Re: Mandalong Southern Extension Project (SSD 5142) – Response to PAC Review Report

Attachment 1 - Response to PAC report recommendations

Figure 3: Centennial's Indicative Extraction Schedule (not binding)

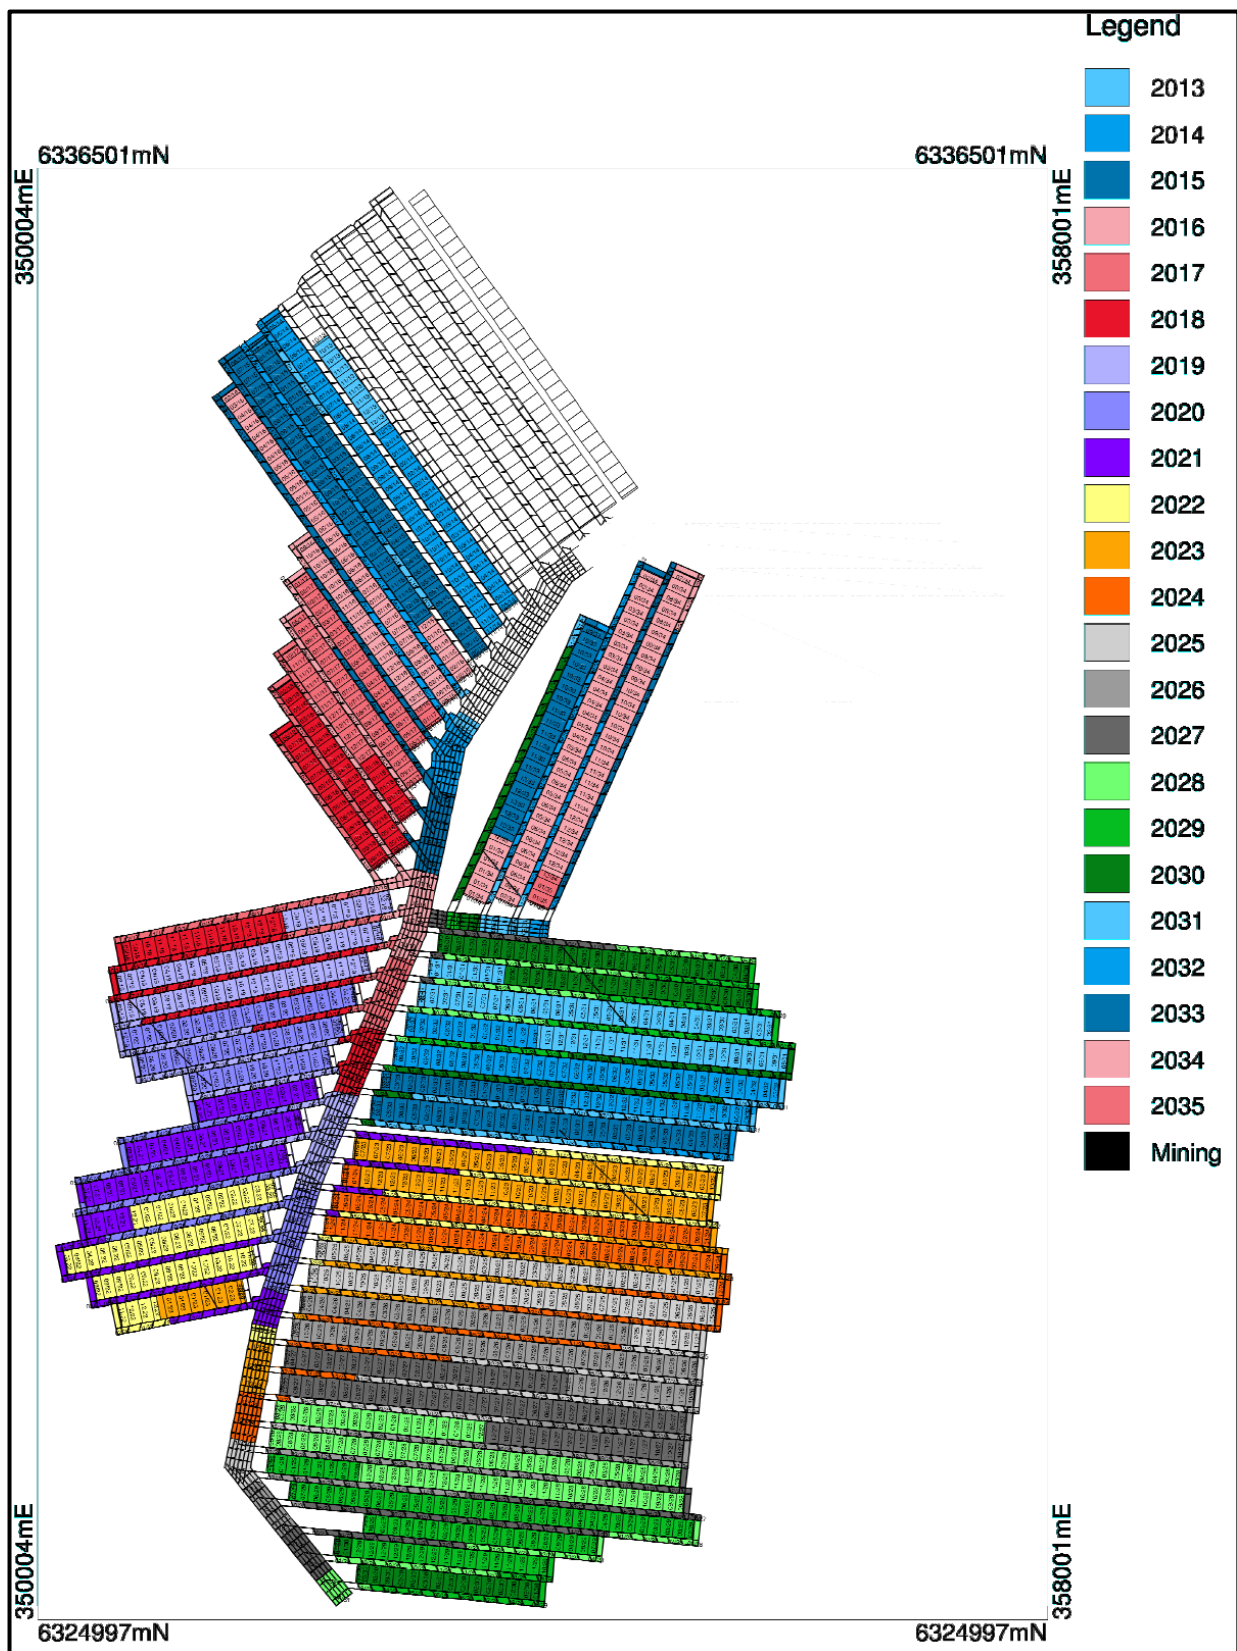
- 1. That the Applicant provides a predicted timeline of longwall extraction, including a plan showing the progression of longwalls over the 25 year project life for inclusion in the consent.**

A plan detailing the indicative timeline of longwall extraction, including the progression of longwalls over the 25 year project life is provided as **Attachment 2**.

Figure 7: Relocated TL24 Transmission Line

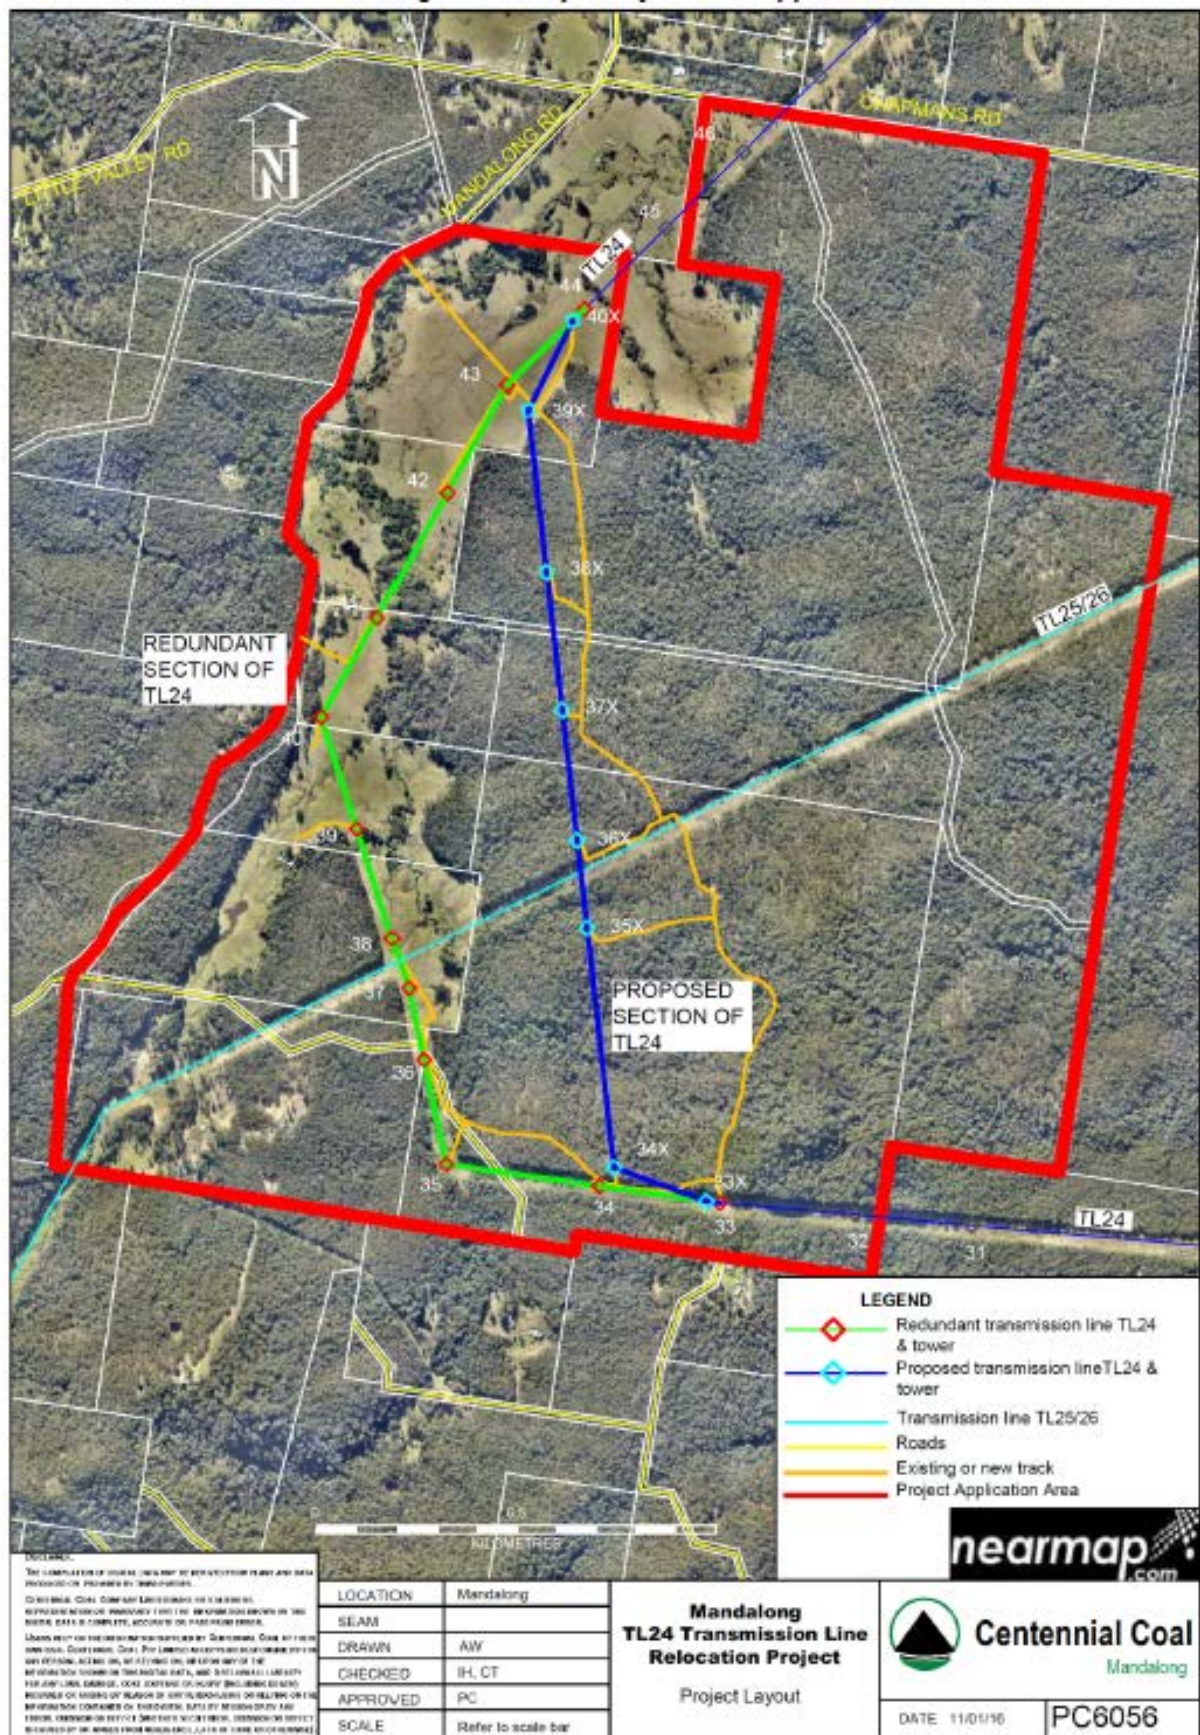
- 4. That confirmation is sought from Transgrid that an appropriate level of consultation with the Applicant has occurred and that the proposed draft conditions are suitable.**

Centennial Mandalong has undertaken extensive consultation with TransGrid throughout the Project in regards to potential impacts on TransGrid owned Infrastructure. TransGrid have determined a section of the Transmission Line 24 (TL24) will be required to be relocated as a result of the Project and will be subject to a separate development application. In addition, TransGrid have identified a programme of works required to transmission line towers to mitigate the risk of impacts. Contact details for the relevant TransGrid representative for the Department of Planning and Environment to contact were provided on 15 April 2015.
